Householder Proforma

Application Ref: 2022/0494

Address: 7 Ingbirchworth Road, Thurlstone, S36 9QN

**1 Proposed Ground Floor GA Plan**  
1 : 100

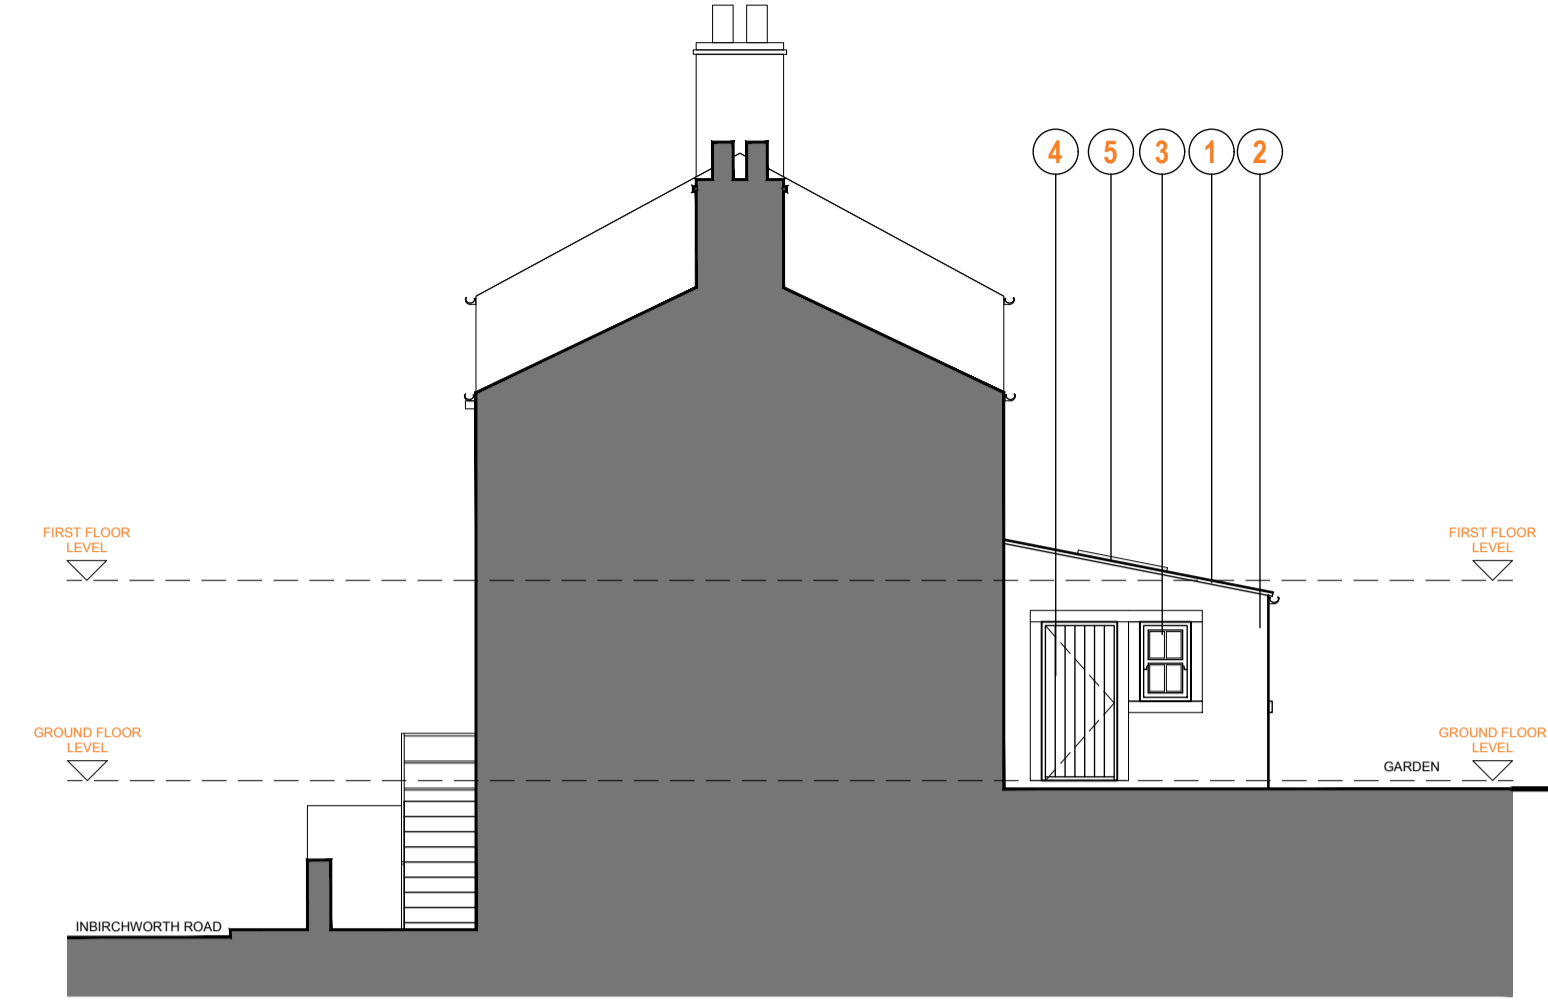
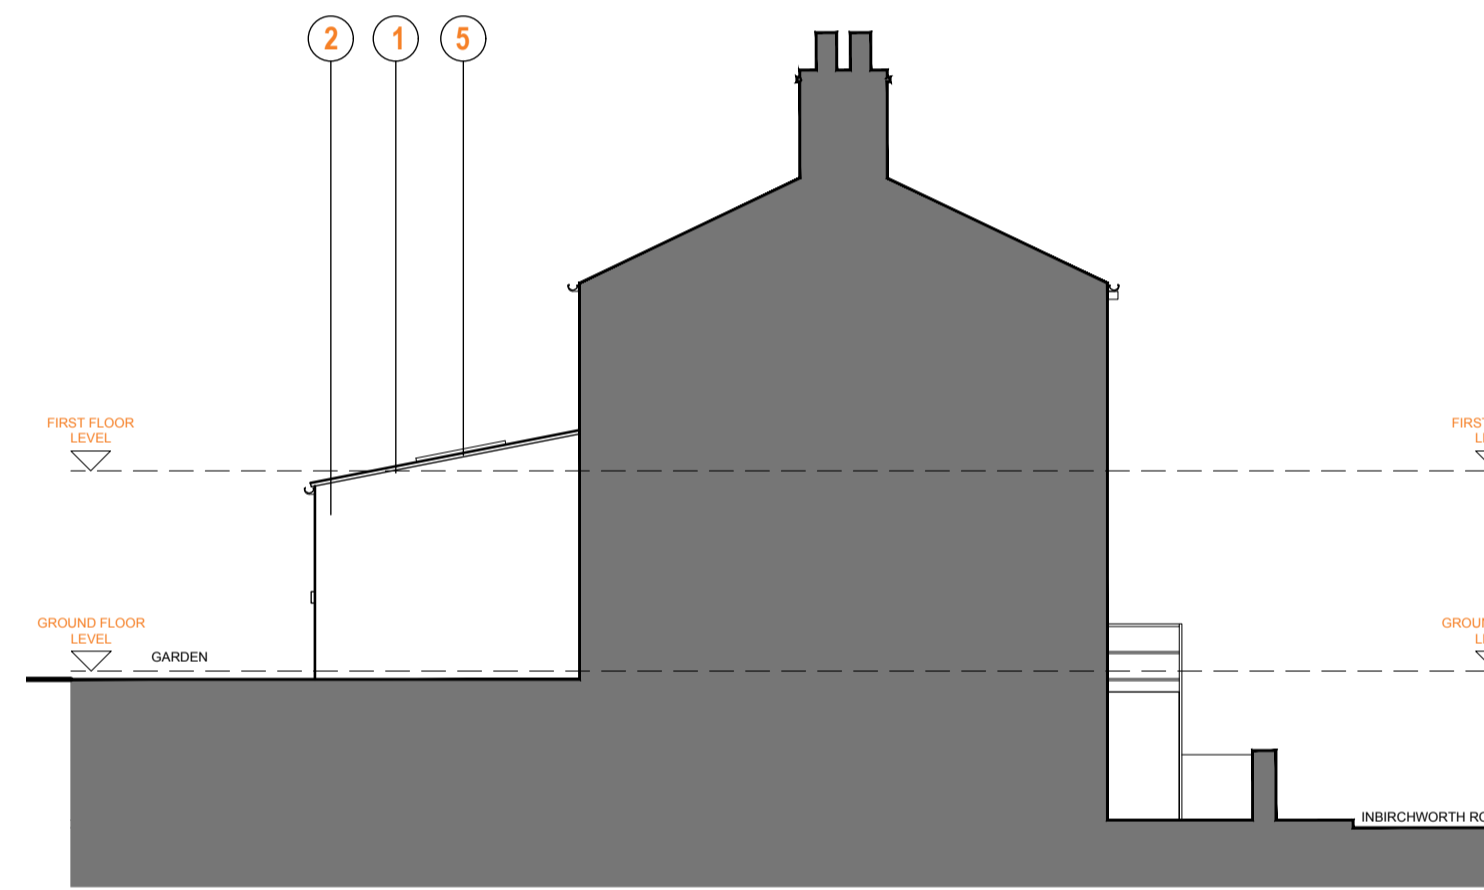
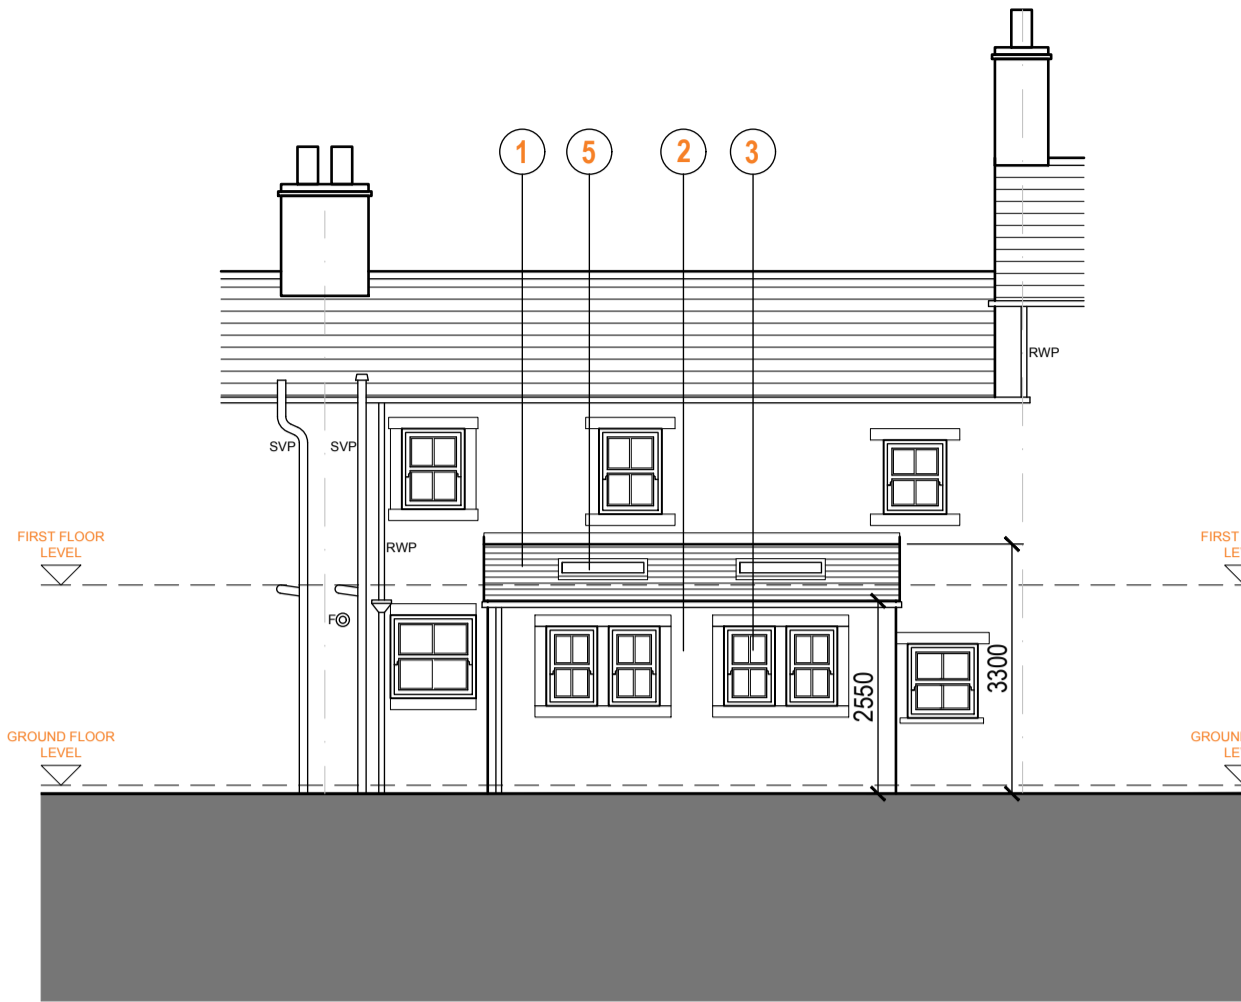
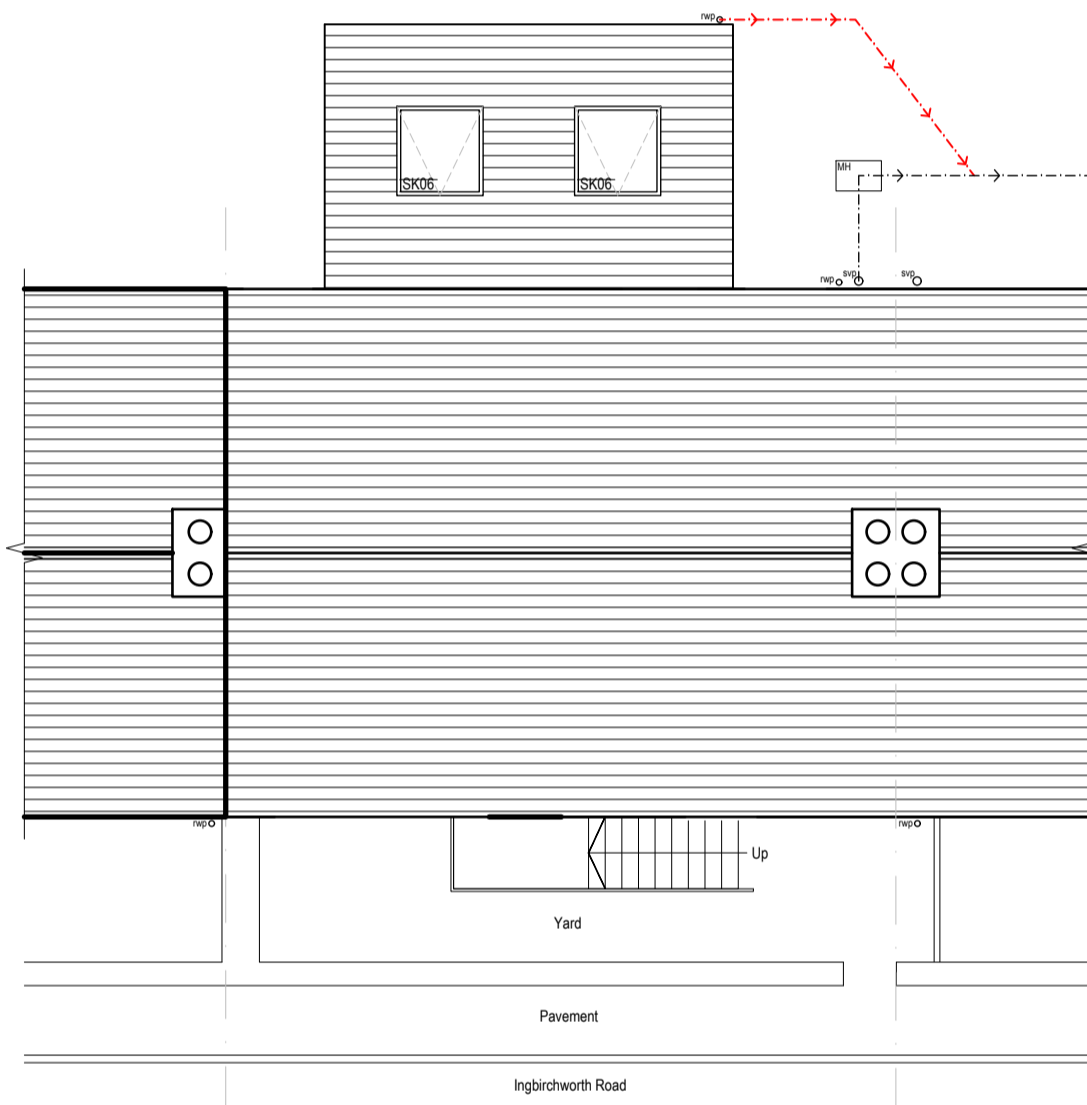
Tony Wiles Conservation Officer – Initial concerns. Some sort of extension to the rear may be acceptable but the currently proposed 4.5m projection seems excessive and this both makes the monopitch uncharacteristically slack and impinges on the setting of the neighbouring 9 Ingbirchworth Road (<https://historicengland.org.uk/listing/the-list/list-entry/1314706>). The design of the extension is essentially ok and the details and materials proposed are acceptable, however. This has been discussed with the architect and a reduced projection of 3m sought.

No objection to the amended plans, the extension is less intrusive into the setting of number 9 Ingbirchworth Road. The application form and plans are quite specific so no need for further conditions.
